Rezoning Transportation Analysis

Petition Number: 2020-167

General Location Identifier: Tax ID 07909935

Revision Log:

SCHEMATIC SITE PLAN

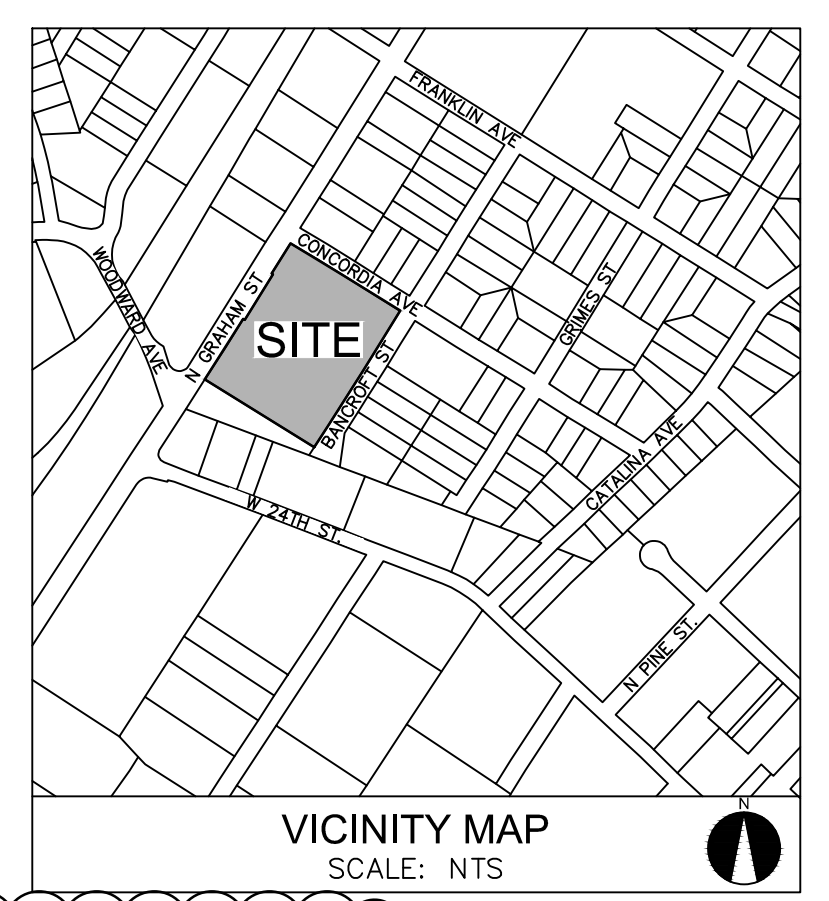
1. ~~**Outstanding** (site plan dated 01/11/21) **Curblines:** The proposed zoning district has a setback measured from back of the existing or proposed future curblines.~~
 - a. ~~**North Graham Street:** Location of curb and gutter needs to be moved 32.5 feet from road center to proposed back-of-curb, to accommodate the future 4 lane Avenue road cross section with buffered/separated bike lanes.~~
 - b. ~~**Concordia Avenue:** Location of curb and gutter needs to be installed at the existing edge-of-pavement.~~
 - c. ~~**Bancroft Street:** Location of curb and gutter needs to be installed along the property frontage, according to CLDSM standard detail number U-03A *Local Residential Wide Street Typical Section*, from road centerline.~~

~~Label and dimension the curb and gutter from the centerline for each road on the site plan.~~

3. ~~Revise site plan and conditional note(s) to commit to dedicate 40 feet of right-of-way from the North Graham Street centerline. Label and dimension the right of way from the road centerline.~~

4. ~~In coordination with NCDOT, revise the site plan and conditional note(s) for the proposed access on North Graham Street to either a right-in/right-out or install a southbound left turn lane if full movement access is desired. If the option to construct a right-in/right-out access is pursued, the median cannot restrict access to existing driveways on the opposite side of North Graham Street.~~

5. ~~Site plan and conditional note(s) revisions are needed to commit to construct bicycle facilities by relocating the existing curbline to accommodate an 8-foot wide buffered bike lane along the North Graham Street property frontage, to meet the City Charlotte BIKES Plan and the goal for improved bicycle connectivity within the City, and to connect to the surrounding network.~~
6. ~~The proposed dwelling units exceeds 12 per acre. Per Chapter 20 Subdivision ordinance, site plan and conditional note(s) revisions are needed to commit to construct an 8-foot planting strip and 8-foot sidewalk along Concordia Avenue and Bancroft Street. The wider sidewalk also meets the Charlotte WALKS Policy.~~

7. ~~A site plan note(s) specifying dedication and fee simple conveyance of all rights-of-way to the City before the site's first building certificate of occupancy is issued is needed. CDOT requests rights-of-way set at 2' behind back of sidewalk where feasible.~~
8. ~~In accordance with the Charlotte WALKS Plan, revise site plan and conditional note(s) to commit to extend the proposed sidewalk and curb and gutter to the existing stub in front of parcel PID (07909936).~~

9. ~~In accordance with the Charlotte WALKS Plan, revise site plan and conditional note(s) to provide sidewalk for pedestrian circulation to proposed buildings E, F, J, and I.~~
10. ~~**Outstanding** (site plan dated 01/11/21) A site plan note specifying that all transportation improvements will be approved and constructed before the site's first building certificate of occupancy is issued is needed. The petitioner may phase transportation improvements if said improvements and phasing are explicitly described in site plan notes.~~
11. ~~**New Comment** (site plan dated 01/11/21) Conditional note (Section F.2.) needs to be revised to clarify that an 8-foot planting strip and 8-foot sidewalk will be constructed along North Graham Street. The site plan needs to be updated to show the curb line being relocated for a buffered bike lane, rather than a 12-foot shared-use path.~~

12. ~~**New Comment** (site plan dated 01/11/21) Conditional note (Section D.4.) needs to be updated to reflect that the streetscape improvements listed within (Sections F.1. and F.2.) will also be completed prior to first certificate of occupancy, in reference to outstanding issue 10.~~
